From: Laura Gibbons
Sent: 04 January 2019 08:22
To: Simon Davis [REDACTED]
Subject: RE: Planning Consultation on Y/97/18/DOC

APPLICATION Y/97/18/DOC

Site Address: Land off Burndell Road Yapton

Description of Works: Approval of details reserved by condition imposed under ref Y/19/16/OUT relating to Condition Nos 5, 6, 7, 9, 10, 11, 12, 15, 17, 18, 19, 22, 23 and 24.

PRELIMINARY ENGINEERING LAYOUT

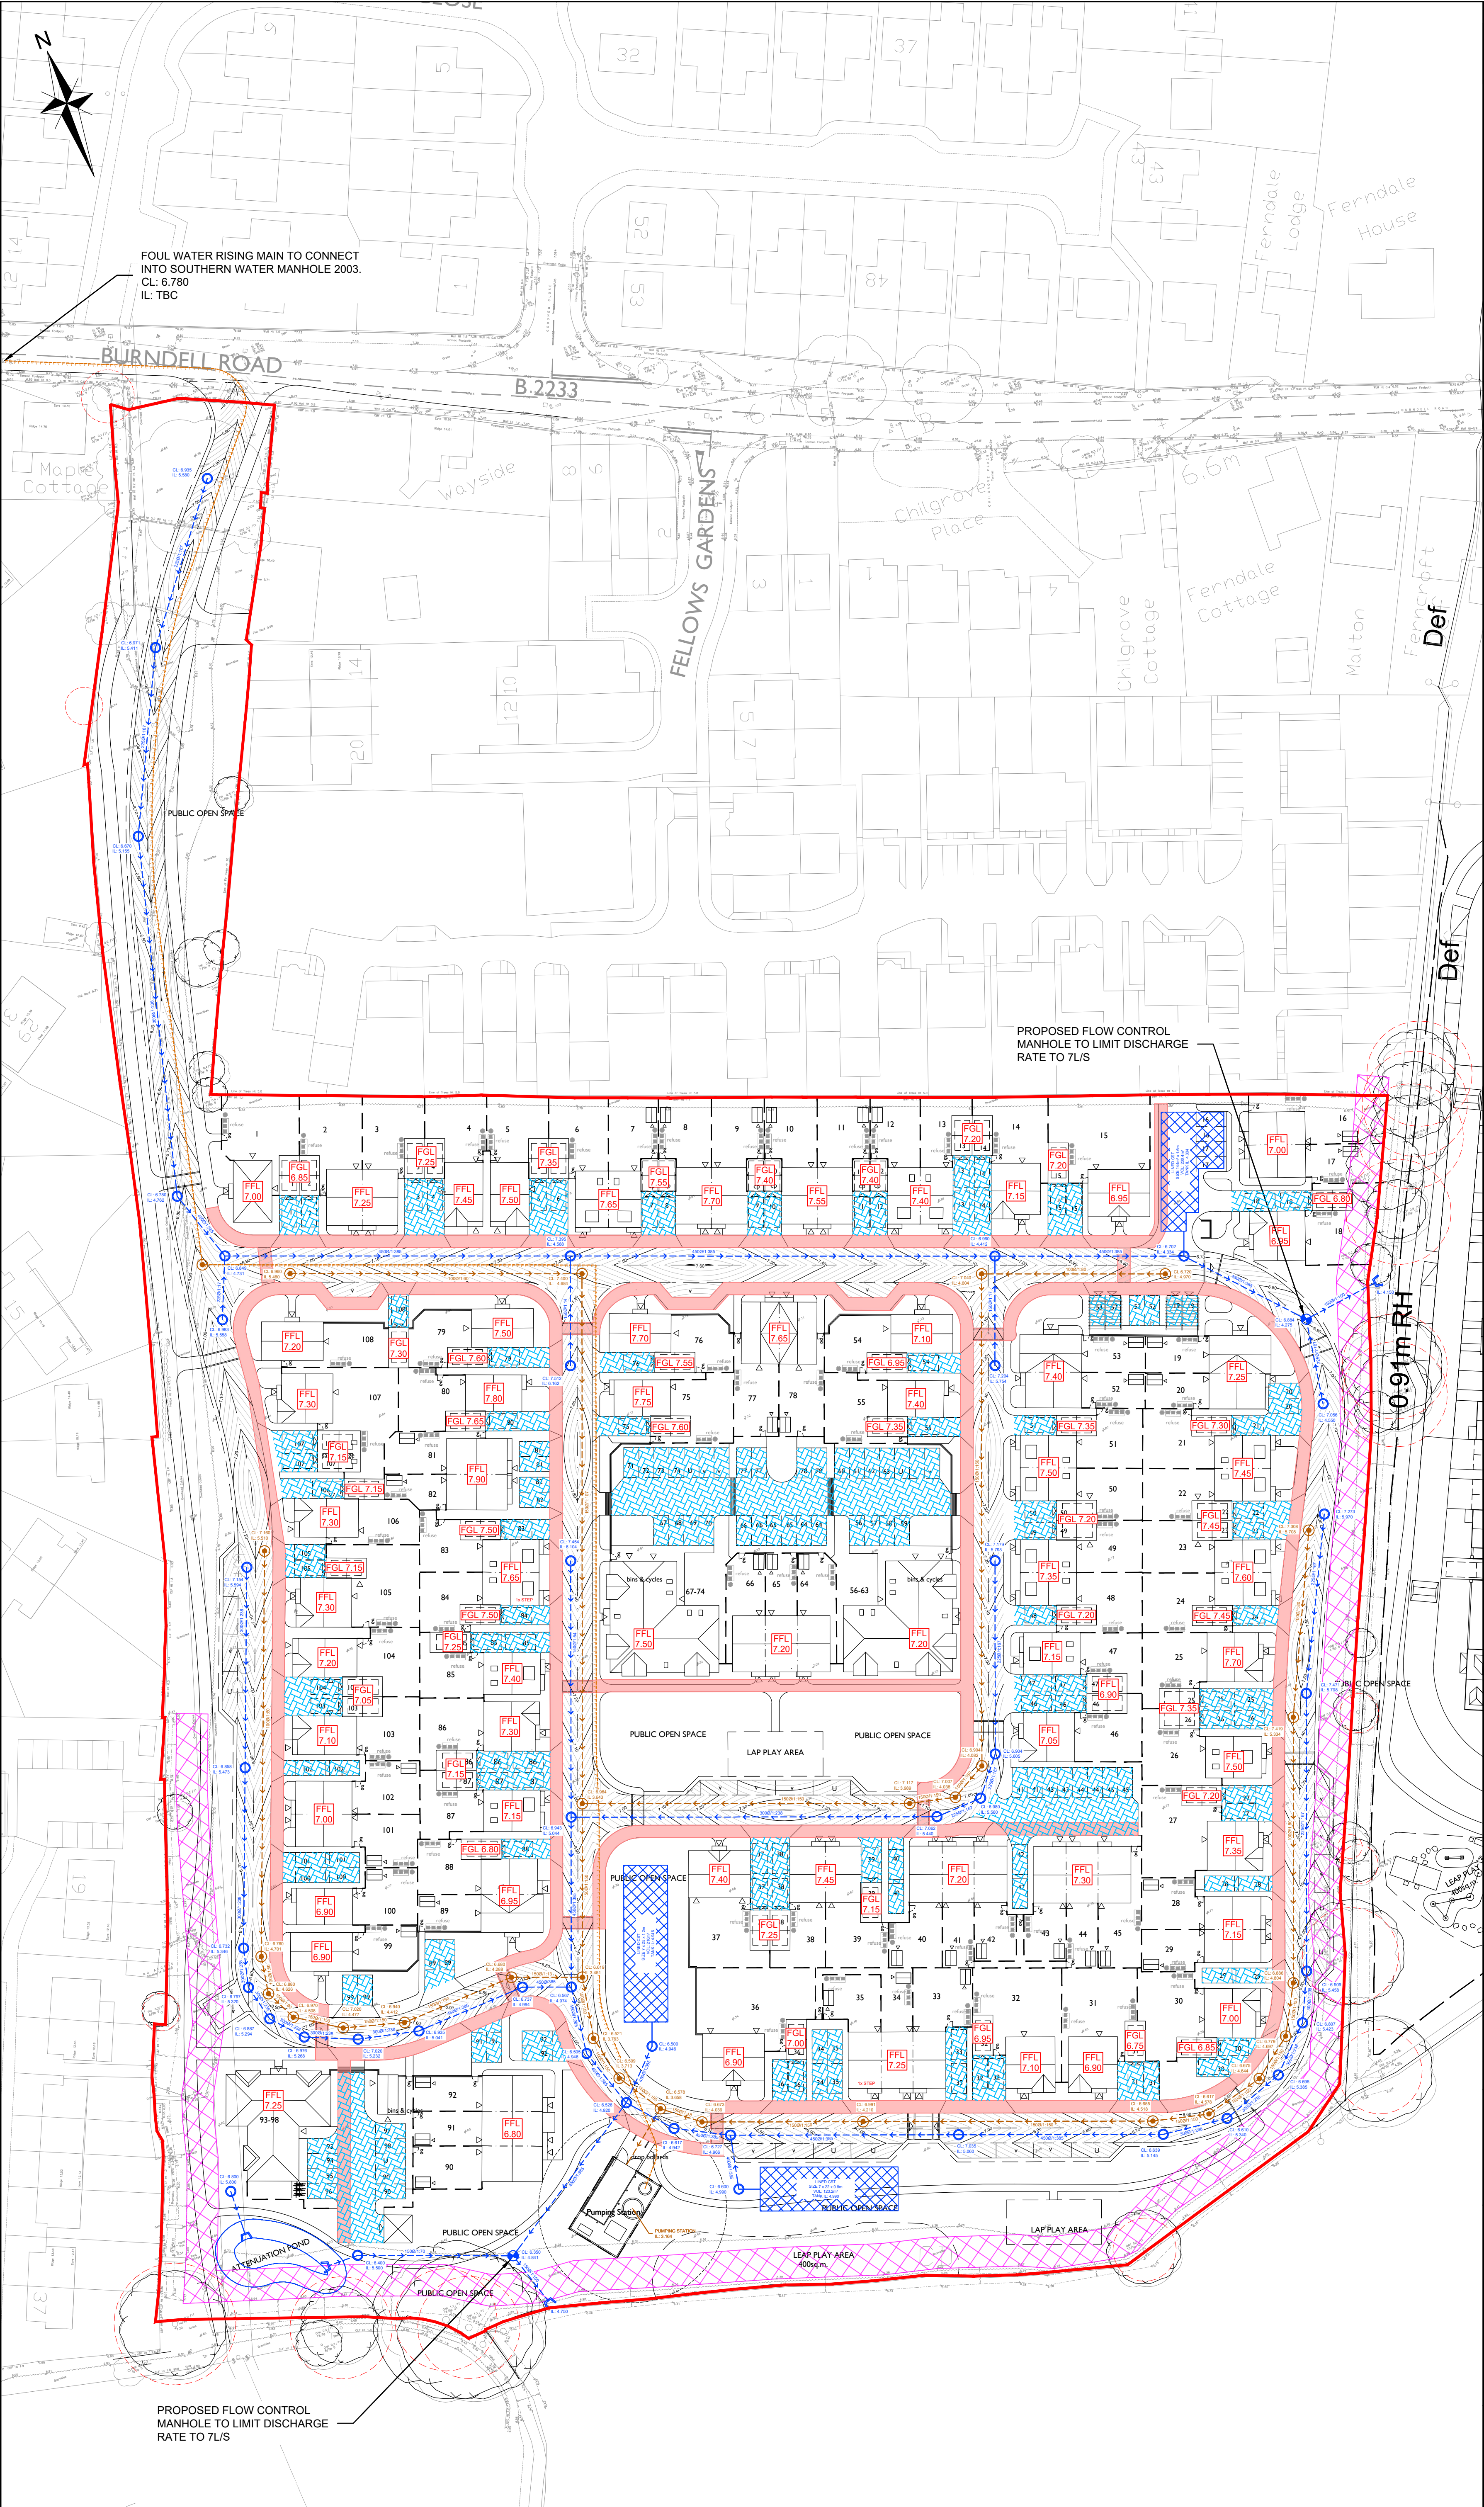
The surface water drainage design has not been agreed, it would be good to ascertain infiltration potential before discharge rates to watercourses are agreed. I will also need to see that ordinary watercourse land drainage consent has been applied for to discharge flows to the watercourse.

A 5m buffer to the watercourse bank is shown to be provided to buildings and fences. However, trees are proposed near to the watercourse. These should be kept away from the bank of the watercourse. And details of how maintenance to the watercourse will occur with the proposed trees should be included.

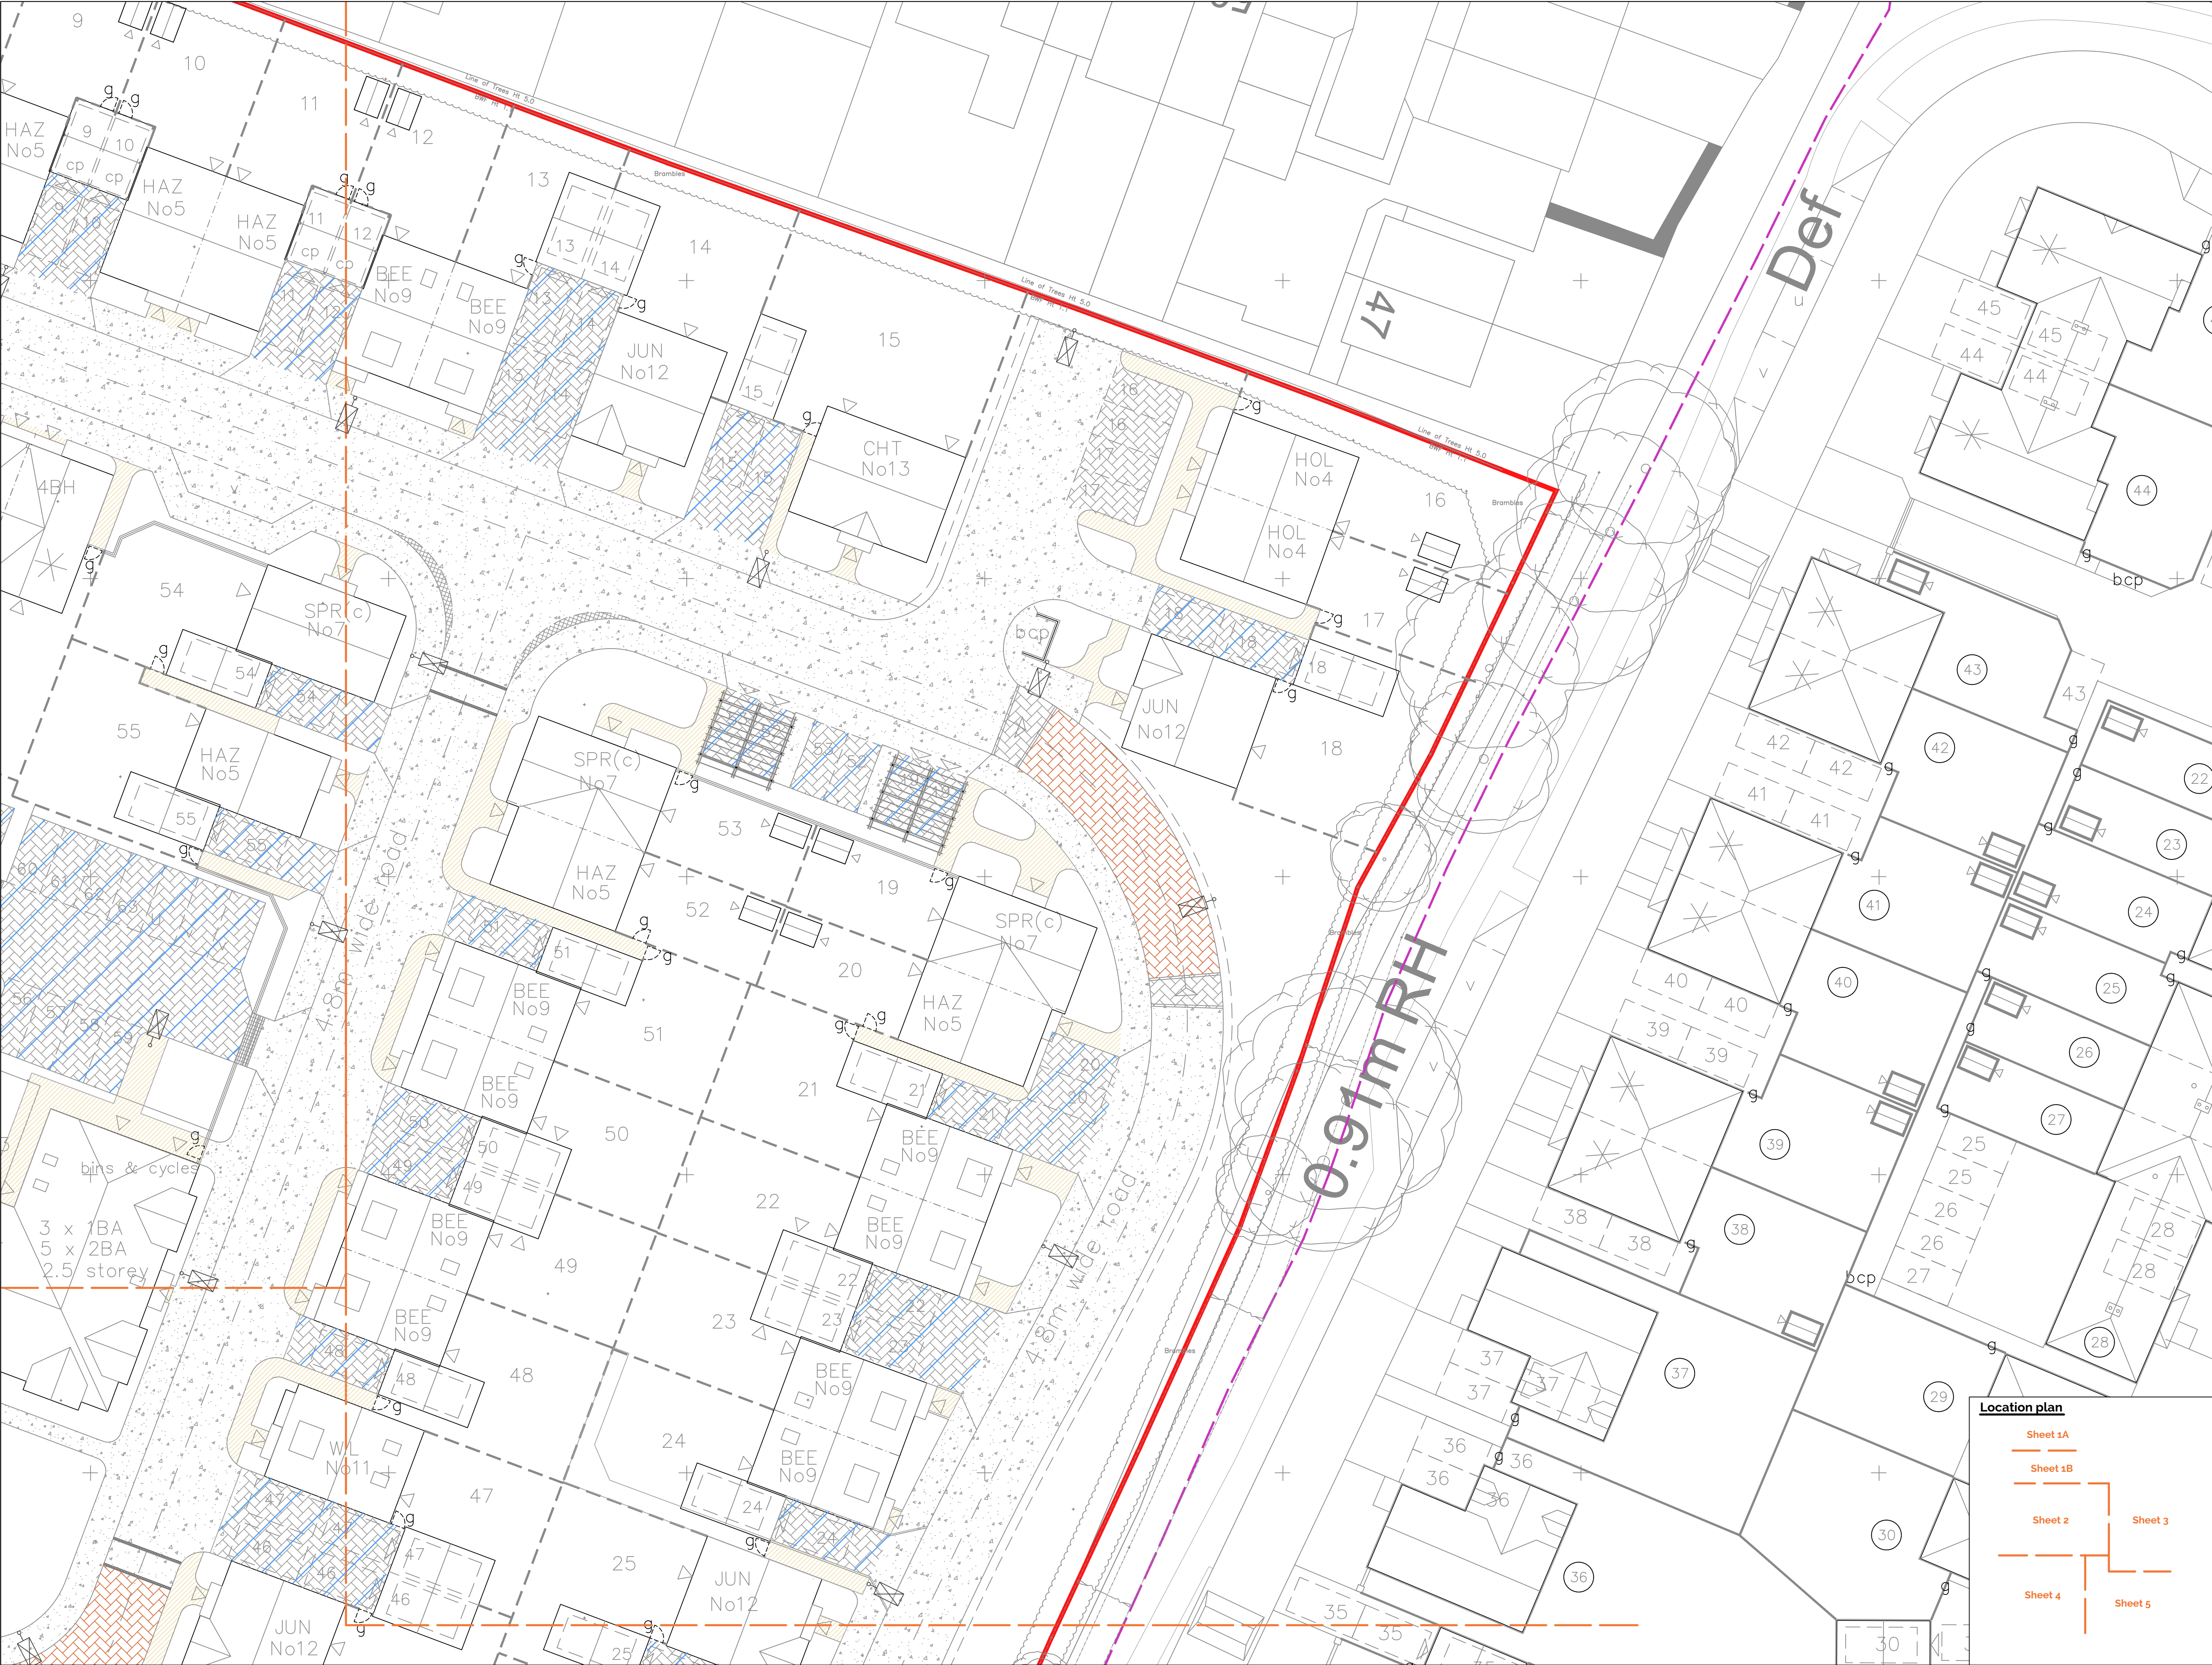
The landscaping proposals currently conflict with the drainage proposals, please ensure the landscaping proposals are not approved until they are appropriately aligned with the drainage proposals. I.e. sufficient easement from trees to attenuation features and watercourses.
